Derby City Council

Team Planning  
Contact Paul Clarke  
Our ref 19/00065/preapp  
Email Paul.clarke@derby.gov.uk  
Tel 01332 641642  
Your ref TR010022  
Date 1 August 2019

### **A38 Derby Junctions Regulation 9 and Regulation 16 Consultation**

Figure 3.2: Construction phases and TM scenarios

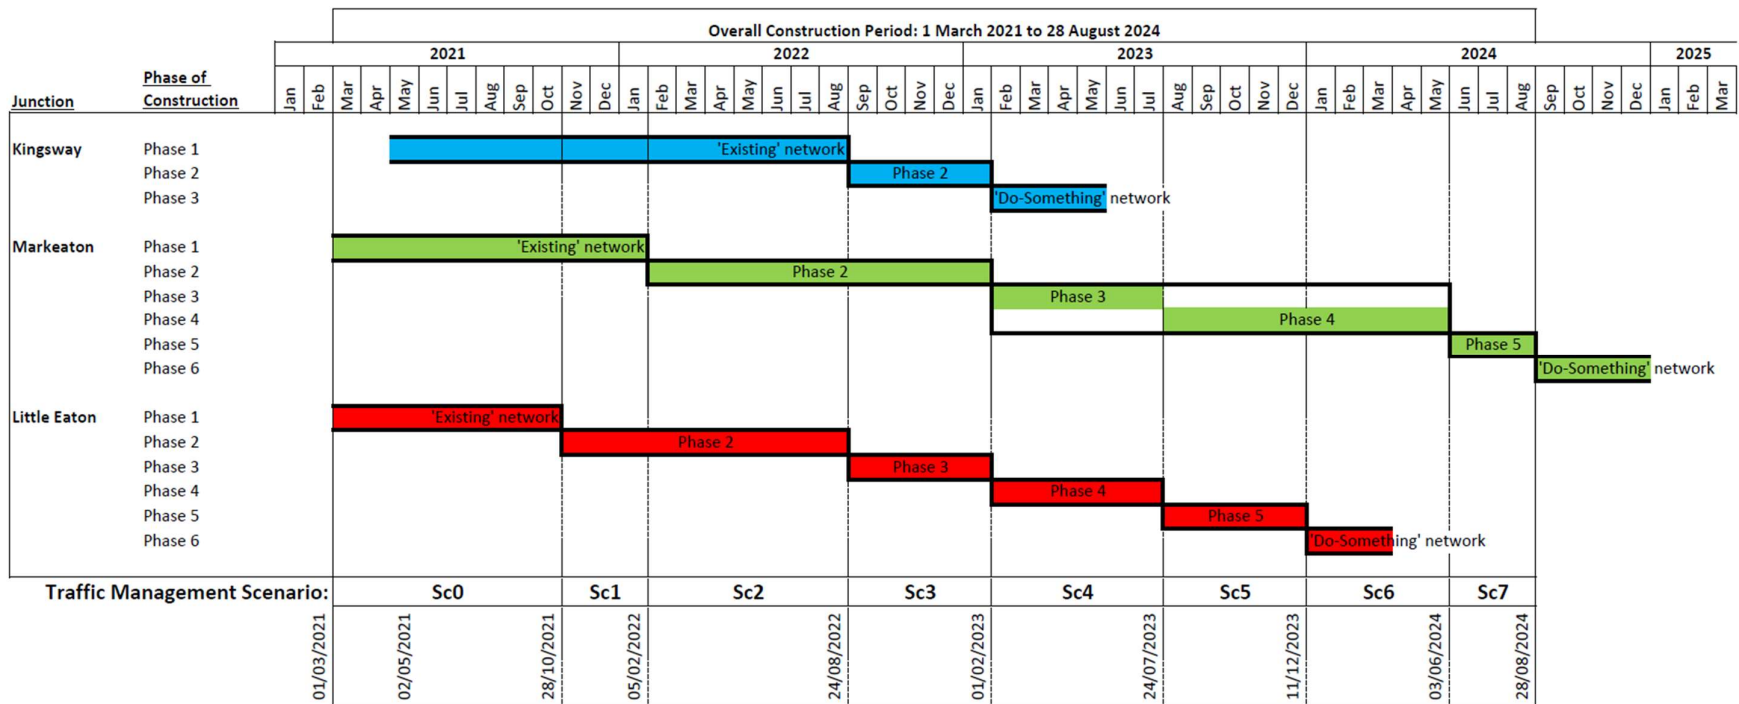
At this stage the phasing plans lack detail in terms of explaining capacity (number of trafficable lanes and lane widths) during the construction phases. In summary, more information needs to be provided on the following:

- Haulage construction traffic in works areas and how this will be managed and interface with adjacent running lanes.
- A clear picture of how phasing sequences at all three junctions will interlink.
- Detailed traffic management plans showing site layouts.
- Clarification on speed limits as the document says it will be 'at least' 30mph during construction phases.
- More detail is required on the coordination of other works in the City as the document makes reference to this. Traffic and Transportation need a clear understanding of Highways England's expectations. Derby City Council does not operate a Road Space Booking system as referenced in the Construction Traffic Management document.
- Incident management strategy.
- More detail on pedestrian management for example controlled crossing points.

There is concern that there is no flexibility in the Traffic Management Plan. The plan may provide the best solution for maintaining traffic flow on the A38(T), however, this could be at the expense of more delays and traffic on Derby's local road network. For example, the document makes reference to queue lengths on the A38(T) during construction, which should not exceed the queue lengths prior to construction. As a consequence does this mean that Derby City's outer and inner ring roads are expected to be utilised to achieve this outcome?
